Conservation Area Advisory Committee

AW/264/17/HH

Single storey rear extension.
This application affects the
character & appearance of the
Aldwick Bay Conservation Area.

18 The Fairway
Aldwick

NEW WEST ELEVATION

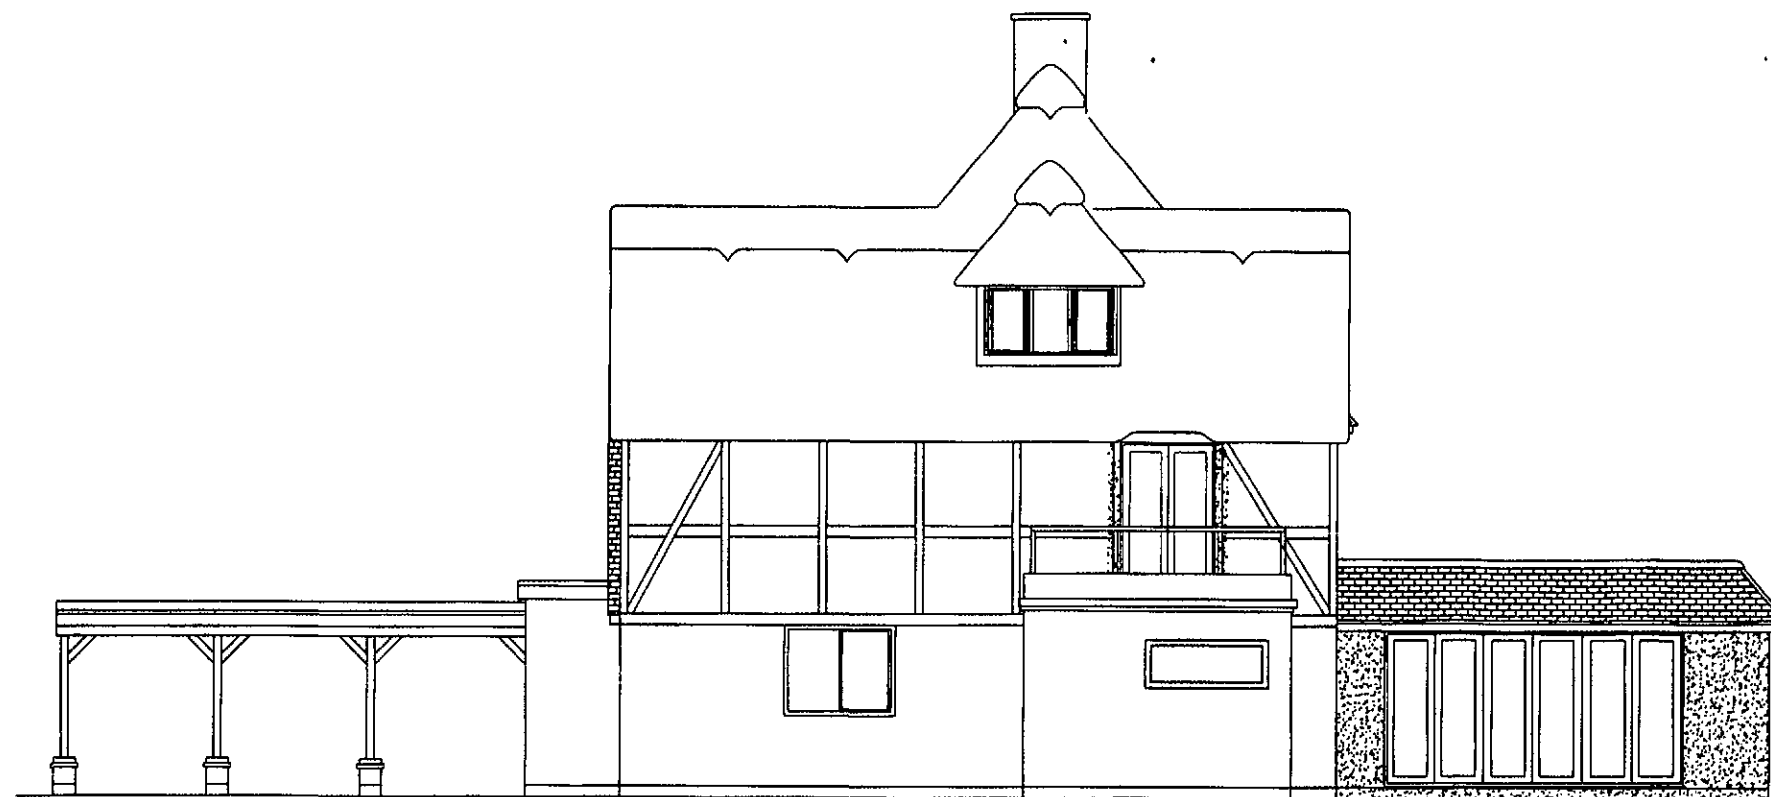
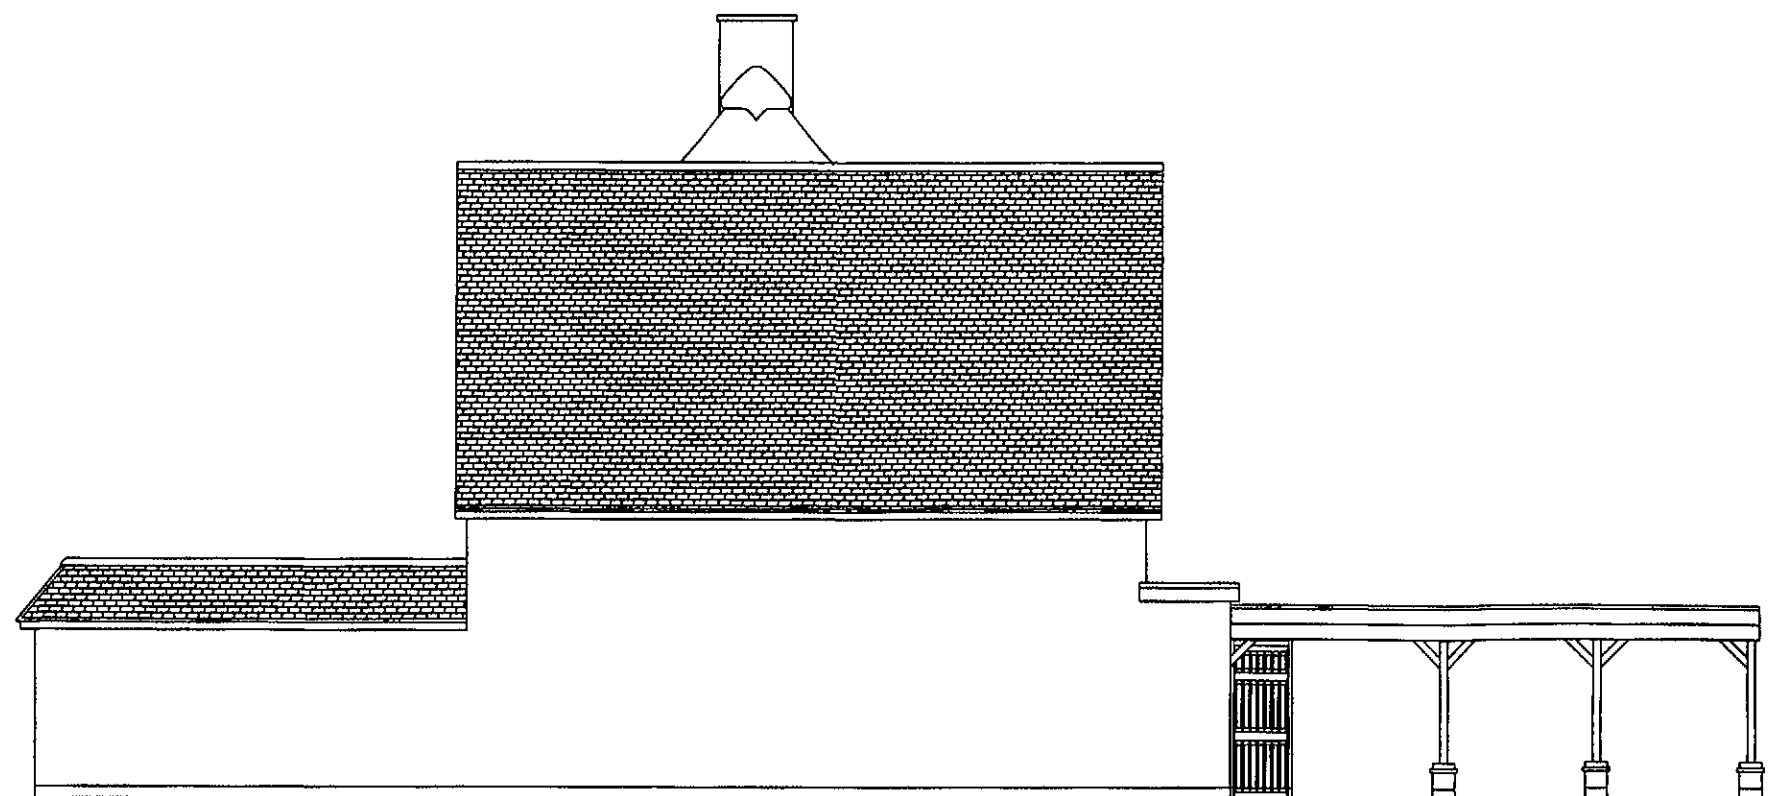
Suggested Conditions: **Insufficient information on the Application for First
Floor Extension. Single storey extension is poorly designed
and doesn't relate to the appearance of the rest of
the house**
